## DECISION DELEGATED TO HEAD OF PLANNING

**Application No:** H17-0021-24      **Applicant:** Mrs J Beattie  
**Proposal:** Residential Development of up to 4 dwellings  
**Location:** 10 Gosberton Road Surfleet Spalding  
**Terminal Date:** 6th March 2024

Indicative Block Plan
Scale 1:200

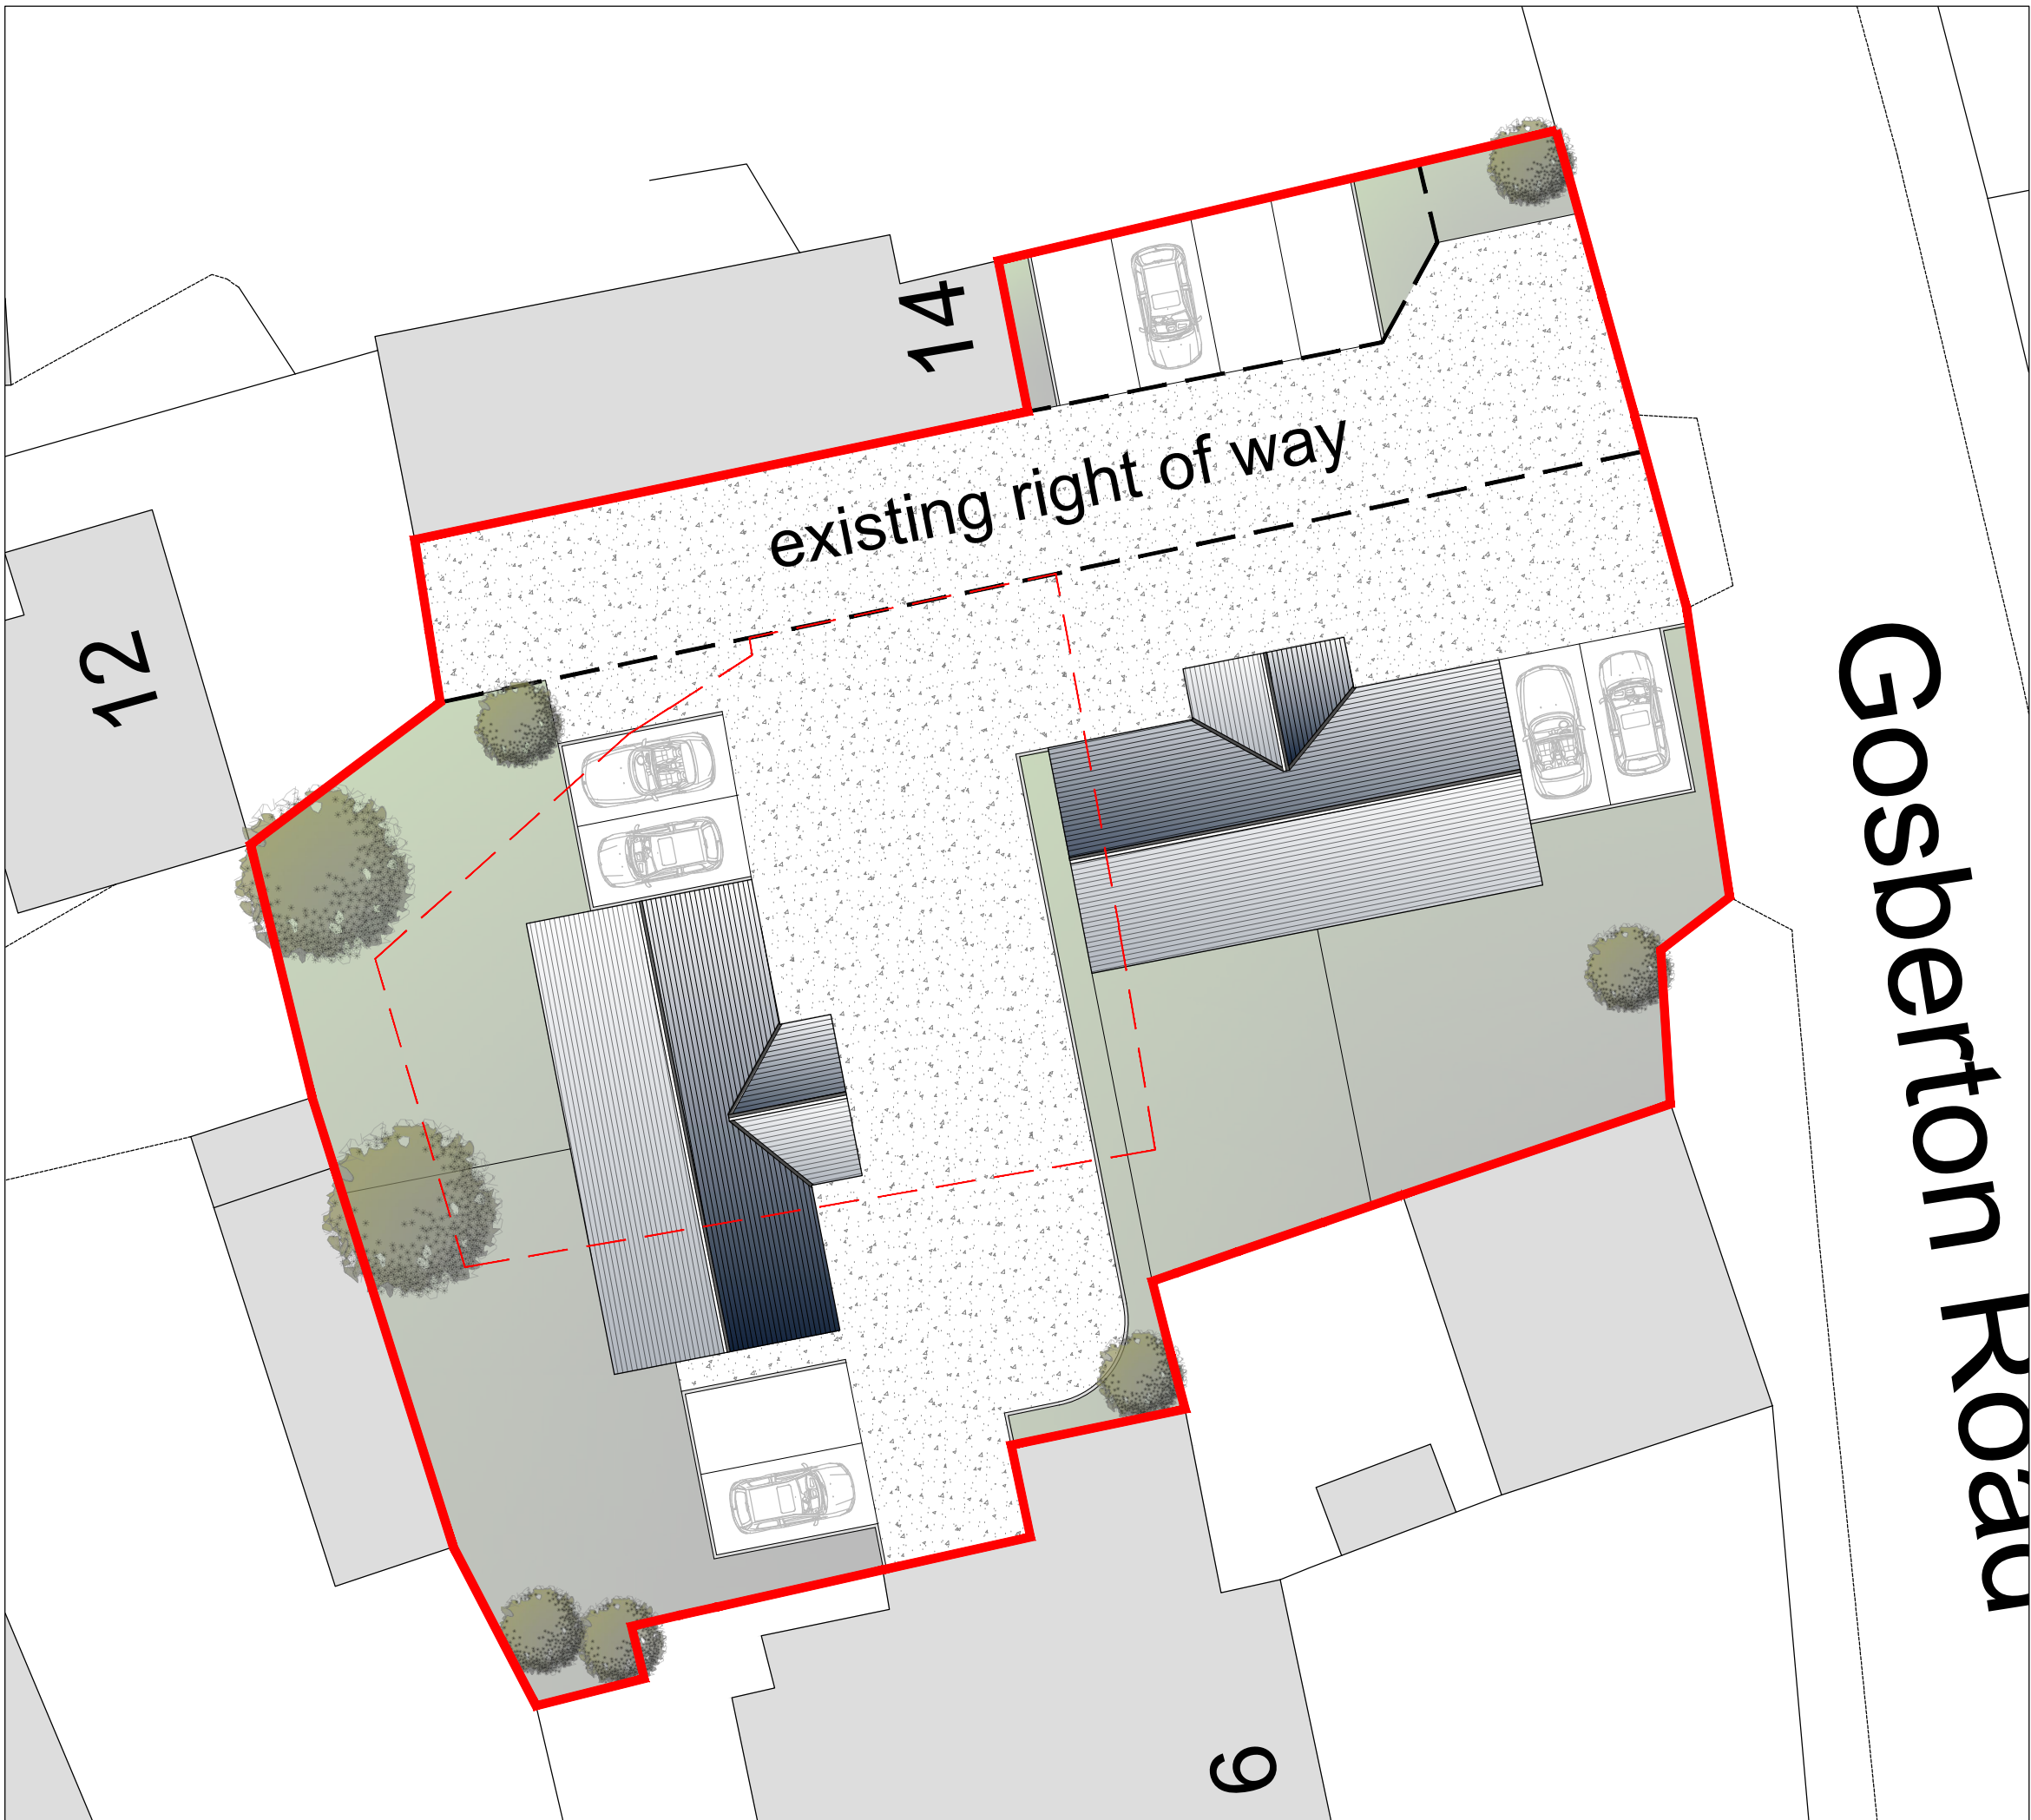
A neighbouring resident has raised concerns in relation to needing to maintain their property due to the fact that the red line is hard up against their boundary. This concern has been echoed by comments from a Parish Councillor and the Parish Council. There is no actual objection, just a concern in relation to maintenance.

It is recognised that number 8 Gosberton Road is hard up against the boundary of the red line to the site. A drain, drain pipes and windows are also hard up against the boundary. There are also windows that look directly onto the application site, but these are secondary windows.

The agent has responded by confirming that a path will be incorporated into the detailed design to allow enough space for maintenance for the neighbouring property. Strictly speaking maintenance is not a direct planning matter, but as this has been highlighted, it would be reasonable to incorporate enough space to allow the neighbour to maintain their property. A note to this effect has been included on the decision notice and a reference to mitigating impacts, including impacts on number 8 Gosberton Road, has also been included within condition 4 which refers to mitigating impacts on adjoining development. This condition does mainly relate to levels but it is considered that the detailed design can take into account the site circumstances.

Indicative Front Elevation
Scale 1:100

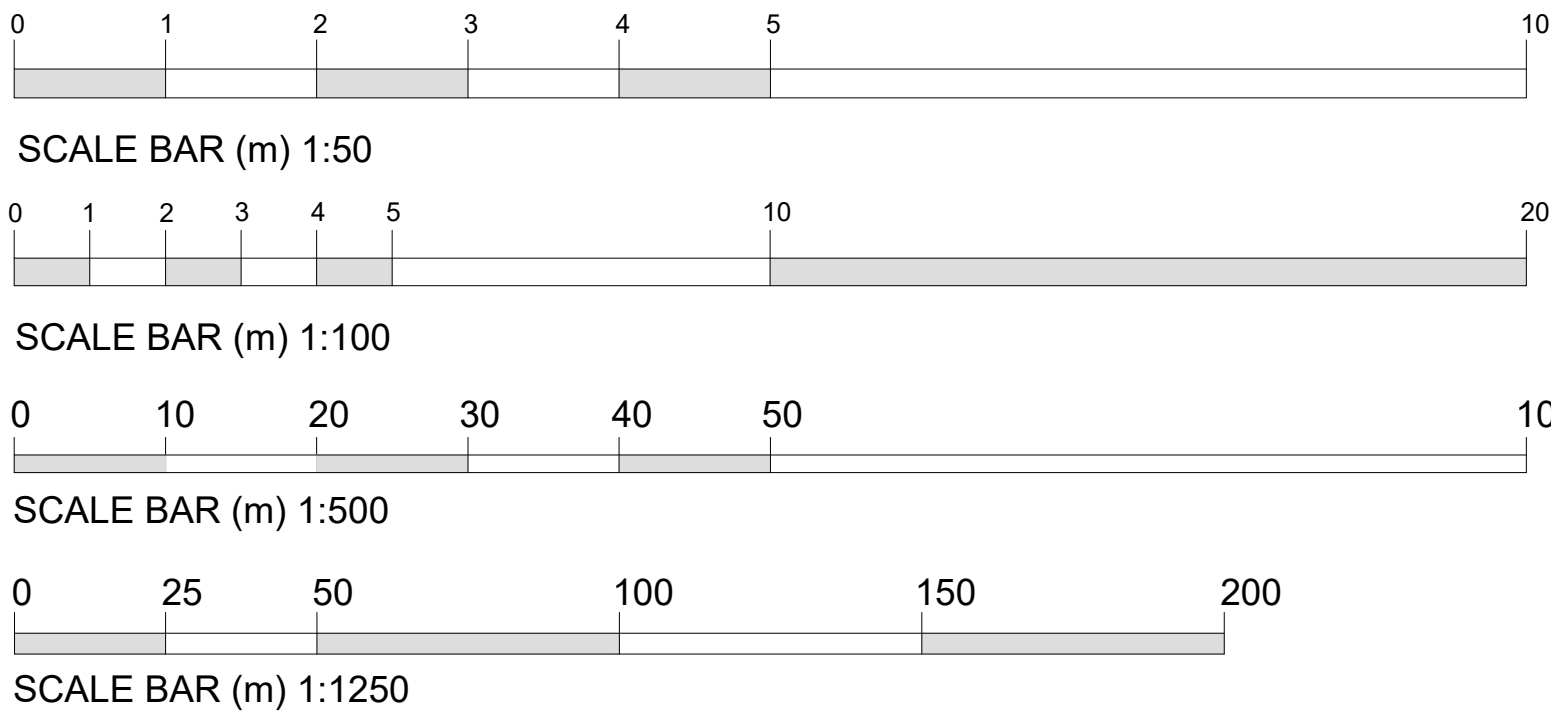
It is recognised that the proposal is outline. Current site is not positive on local historic environment. Indicative elevations appear too plain and lacking in sympathy with neighbouring development. Proposals should improve the qualities of the village, so a high quality of design will be expected of the final proposal to satisfy Policies 2 (paragraphs 2 & 9), (Paragraph 1) and 19 of the SELLP.
